3 August 2021
Ref 20355

SSD 8859
PROPOSED SUBDIVISION
1111-1141 ELIZABETH DRIVE, CECIL PARK
STAGING/TRAFFIC MATTERS

I refer to Transport for NSW's (TfNSW) email from Tom Bertwistle to AE Design Partnership, dated 27 July 2021, requesting additional information (RFI) in respect of the abovementioned development proposal. The following information is provided in response to the Staging/Traffic matters raised in Tom's email.

# Temporary Construction Access Prior to Elizabeth Drive & Walgrove Road Upgrade

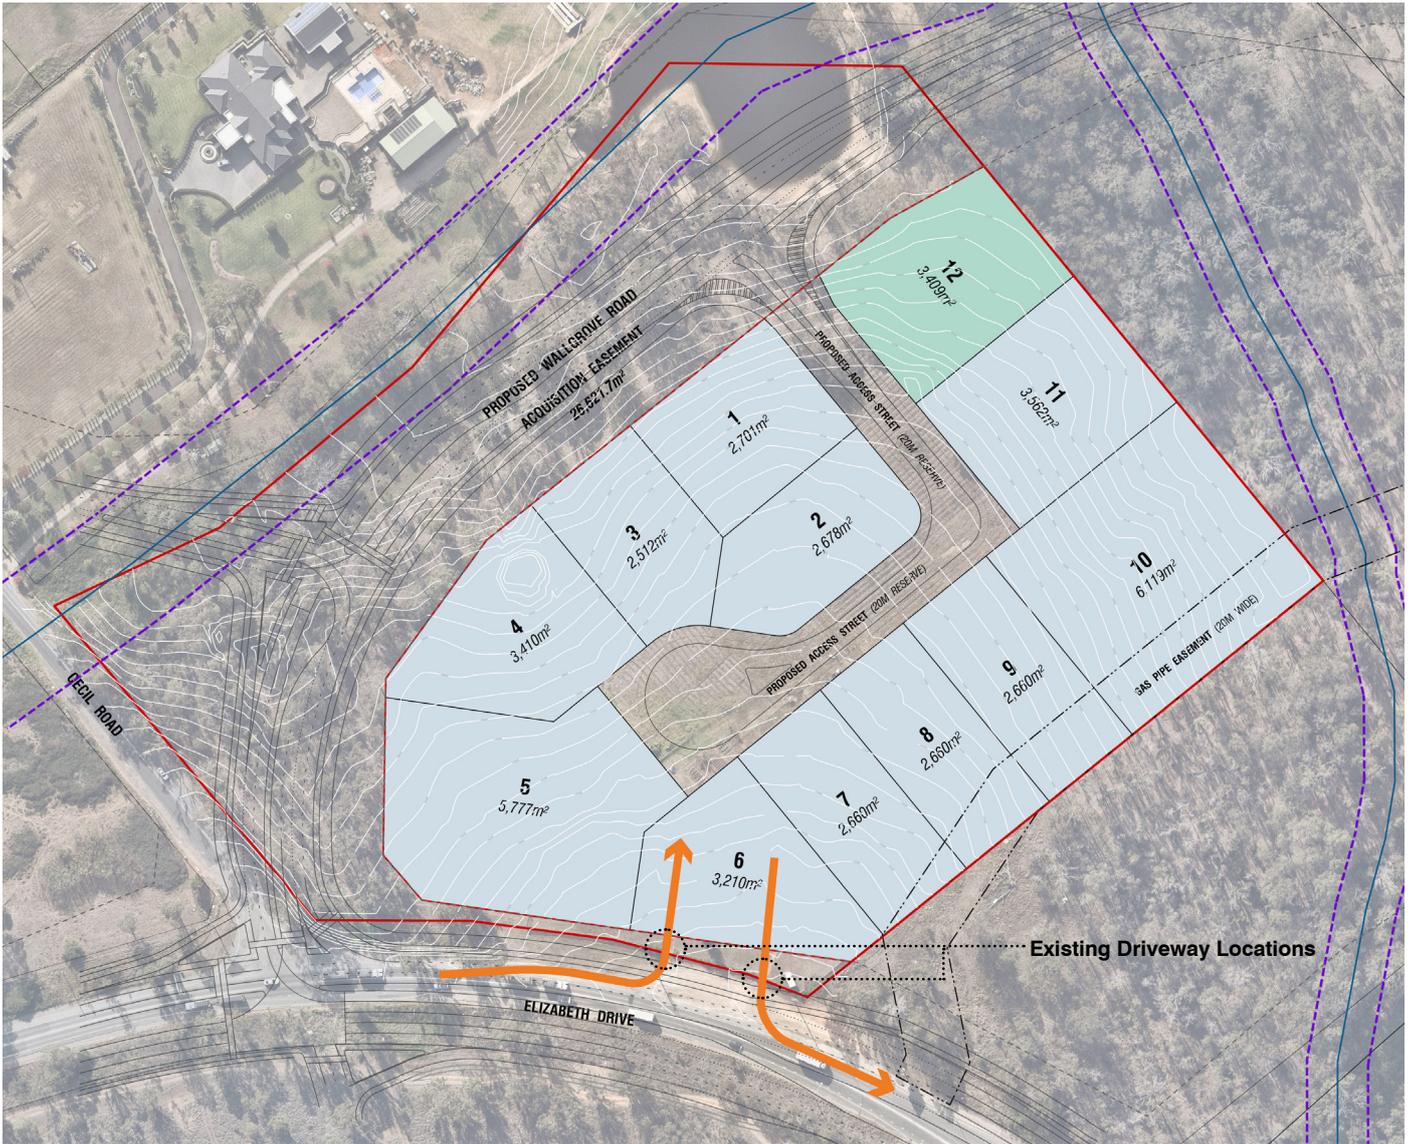
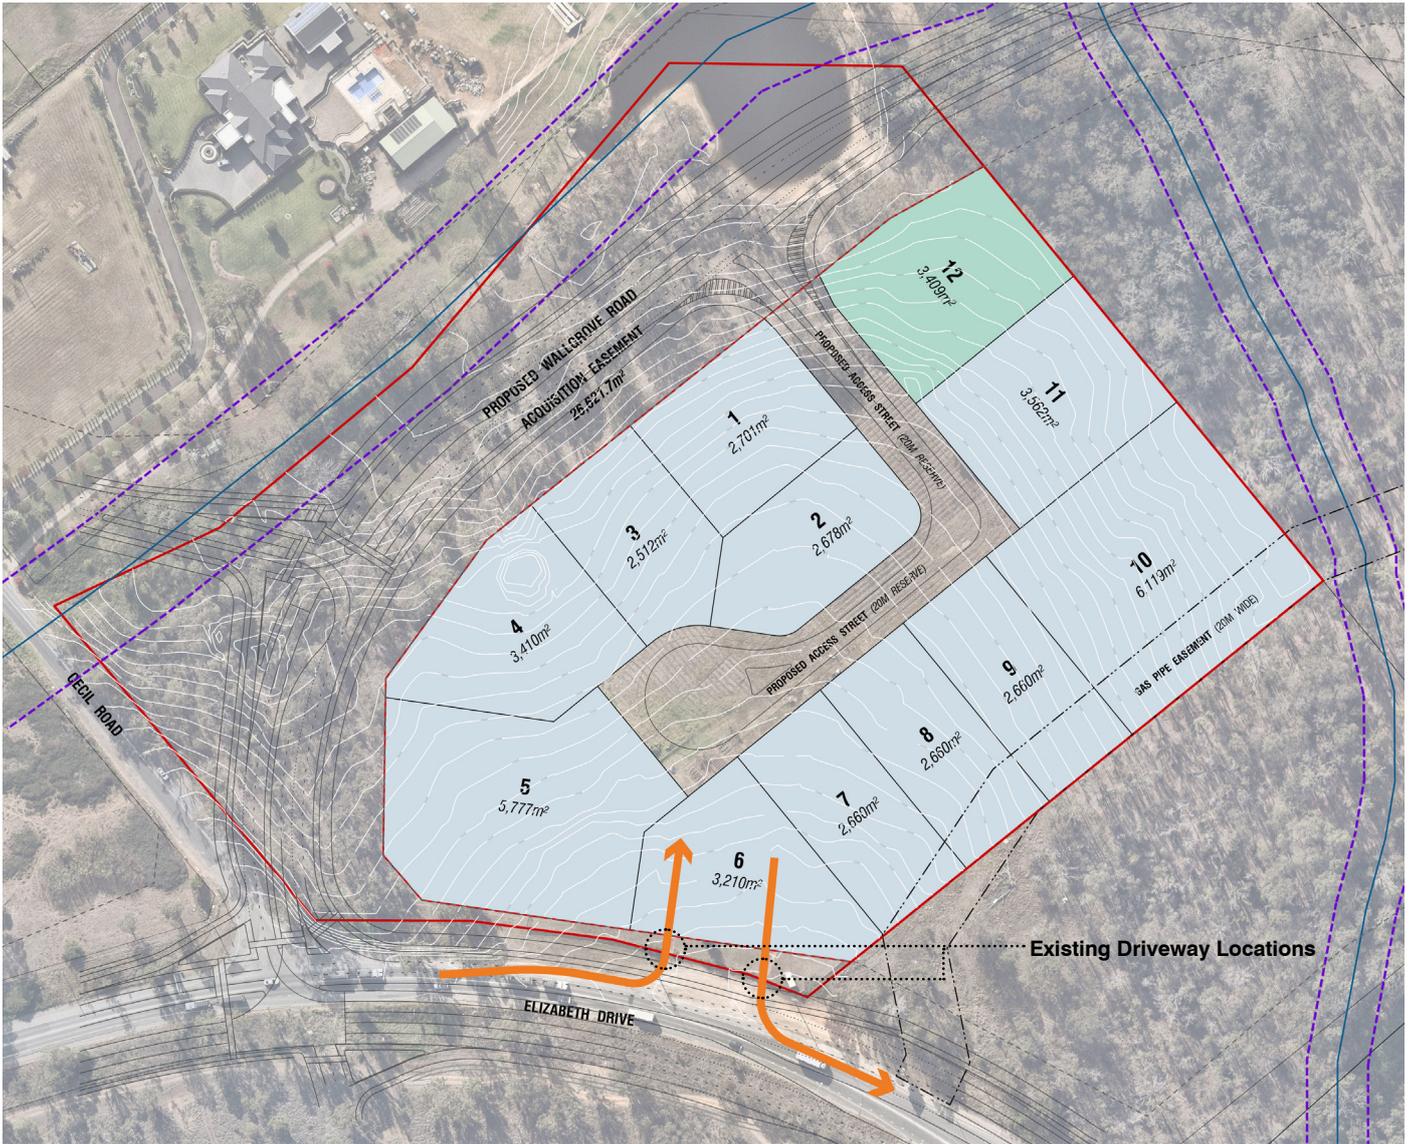
It is acknowledged the RTS proposes access locations to the site during the construction stage, before and during the construction of realigned Wallgrove Rd . However, it would be helpful to include further details on operational access arrangements prior to the completion of Wallgrove Road, and expected timeframes for construction and operation. I.e. How (if at all) is it proposed the development would function if it is completed prior to the opening of the realigned Wallgrove Road.

It is noted concerns over the use of Elizabeth Drive were raised by TfNSW in the original submission of the DA. With construction traffic now proposed off Elizabeth Road, it is suggested further details be provided on the expected traffic levels during the construction stage.

In terms of estimated truck movements during subdivision works on site, it is expected that there will be in the order of 1 x B3 Trailer accessing the site every hour between 10am and 3pm. It is noted that the Applicant maintains ongoing discussions with TfNSW in relation to access into the site in conjunction with the proposed road upgrades associated with the M12 Motorway. Detailed traffic movements will be outlined in a construction management plan, which can be conditions as part of any future consent.

- Construction access to the site would need to be via Elizabeth Drive.

- Construction access to site would be via Elizabeth Drive.
- TfNSW would maintain the current property access/ or any existing construction access on Elizabeth Drive until such time that the new property access/operation access could be provided via the new realigned Wallgrove Road.
- No construction access would be provided via the realigned Wallgrove/Ceil Road

- **Operation access to the site cannot be provided until the realigned Wallgrove/Ceil Road is open to traffic**
- Based on TfNSW current staging and program, the realigned Wallgrove Rd would commence construction at the first stage of construction which is currently scheduled to commence in Q1 2023 with completion around mid to late 2024 with the rest of the project to be completed by End of 2025.
